STATE OF NORTH CAROLINA  
DEPARTMENT OF TRANSPORTATION

July 6, 2022

Subject: **Revised Modification Request for Section 404 Individual Permit, Section 401 Water Quality Certification and Neuse Riparian Buffer Authorization** for Interstate 40 Widening and Improvements from I-440/US 64 (Exit 301) to just north of SR 1525 (Cornwallis Road), including improvements to NC 42 and SR 1010 (Cleveland Road) in Wake and Johnston Counties, Federal Aid Project No. IMNHF-040-4(139)301; TIP Numbers I-5111 and I-4739, Division 5. Debit \$570 from WBS Element 42346.3.1.

PROJECT REFERENCE NO.	SHEET NO.
1-5111/1-4739	49
R/W SHEET NO.	
ROADWAY DESIGN ENGINEER	HYDRAULICS ENGINEER
INCOMPLETE PLANS DO NOT USE FOR R/W ACQUISITION	
DOCUMENT NOT CONSIDERED FINAL UNLESS ALL SIGNATURES COMPLETED

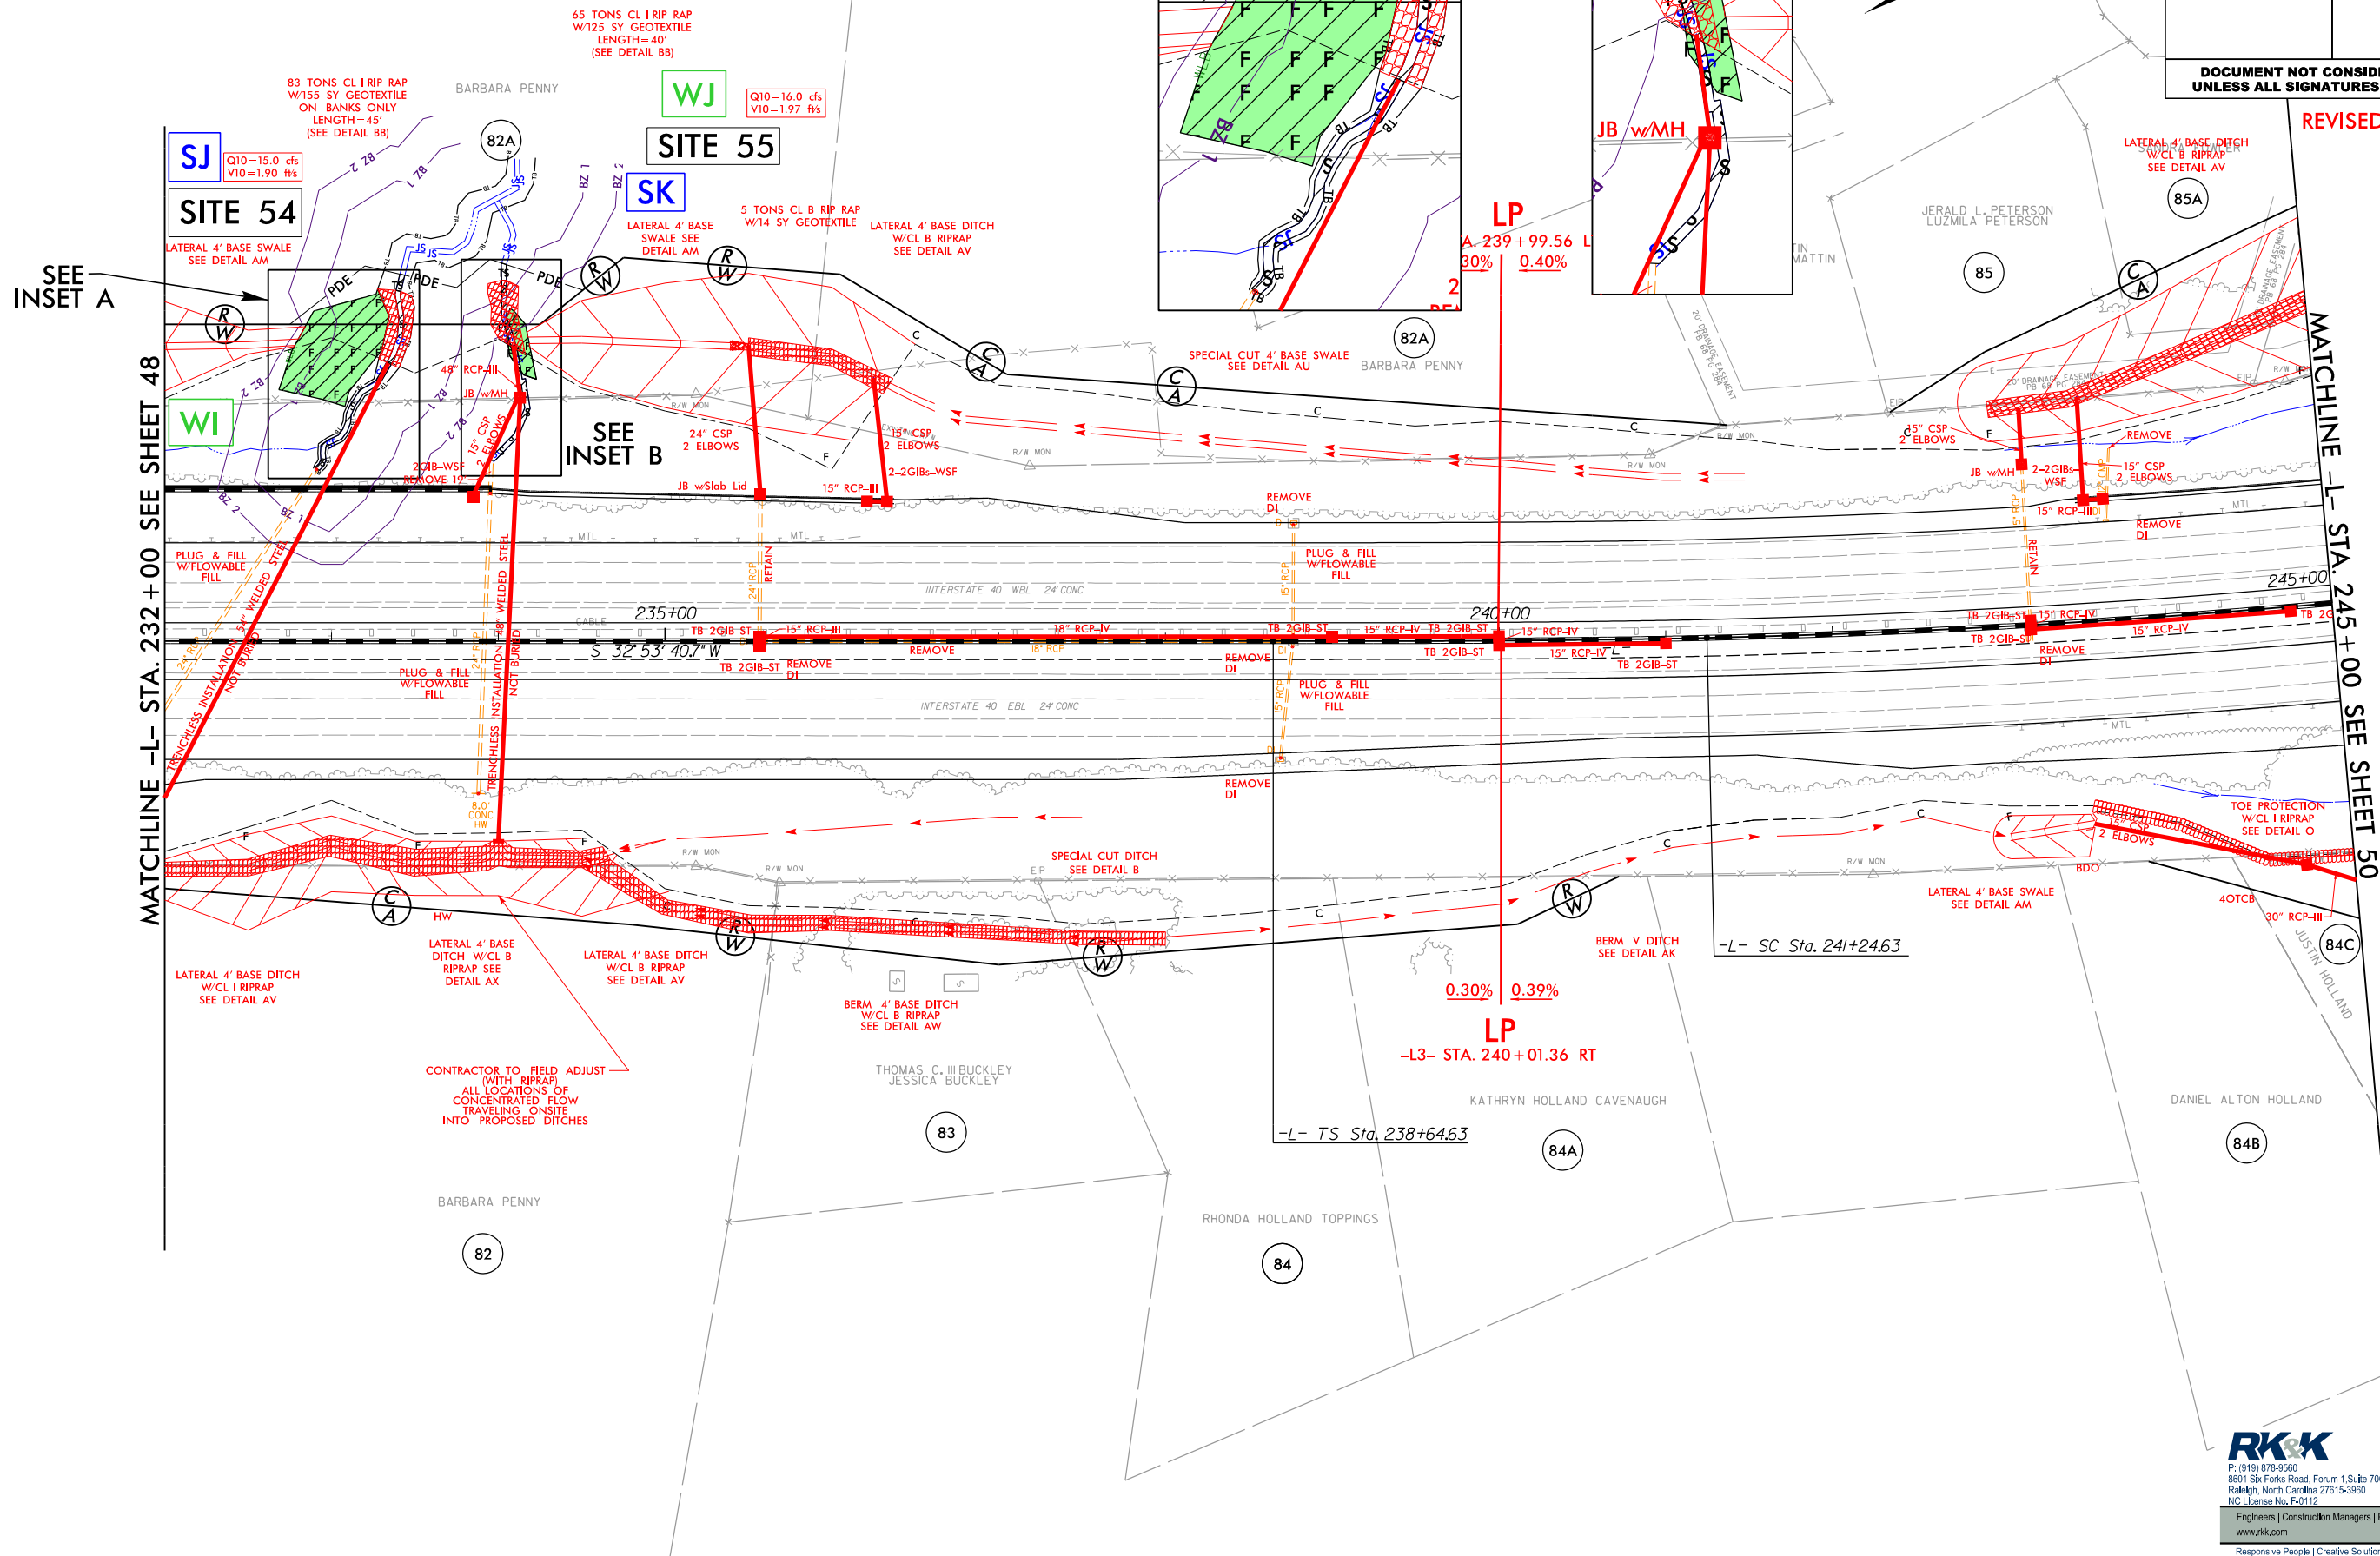
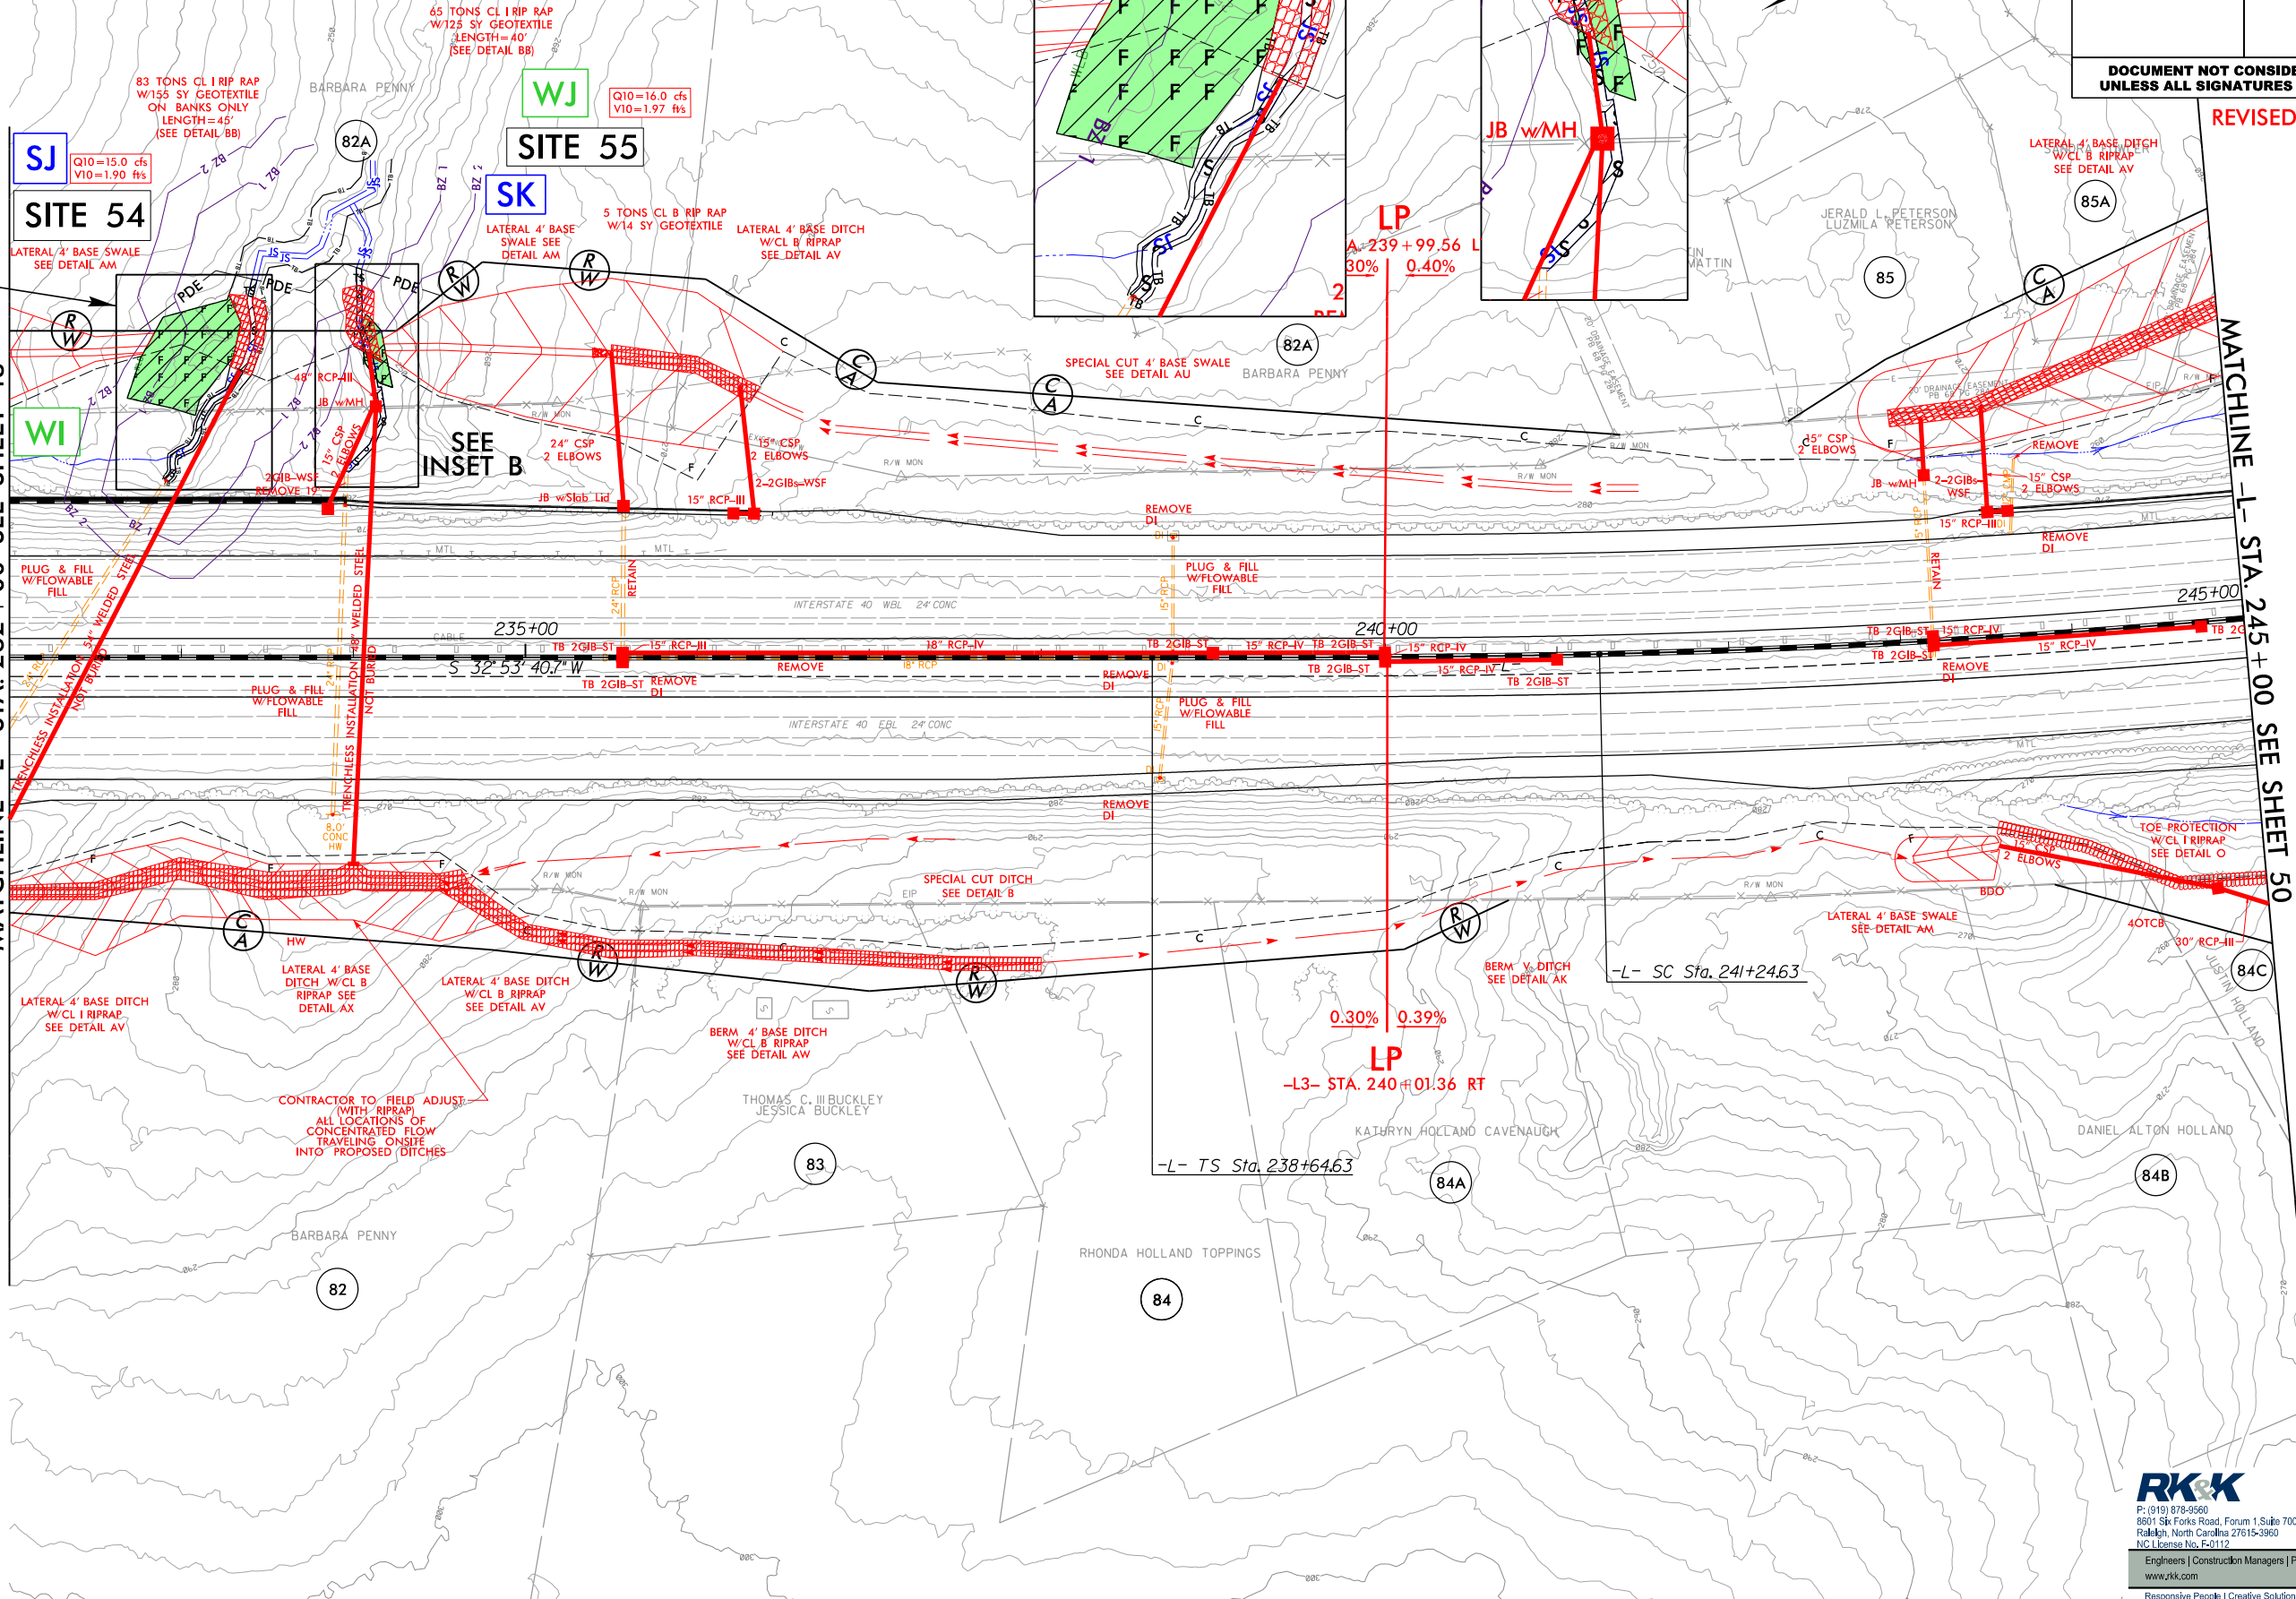
Site 55: Due to repeating erosion events and the general instability of the channel below the outlet of Site 55, the Design Build Team proposes rip rap be added to the flow line to match the length of the previously permitted bank stabilization. This will result in the following changes:

- 40 linear feet decrease in bank stabilization impacts
- 40 linear feet increase in permanent stream impacts
- No changes in buffer impacts
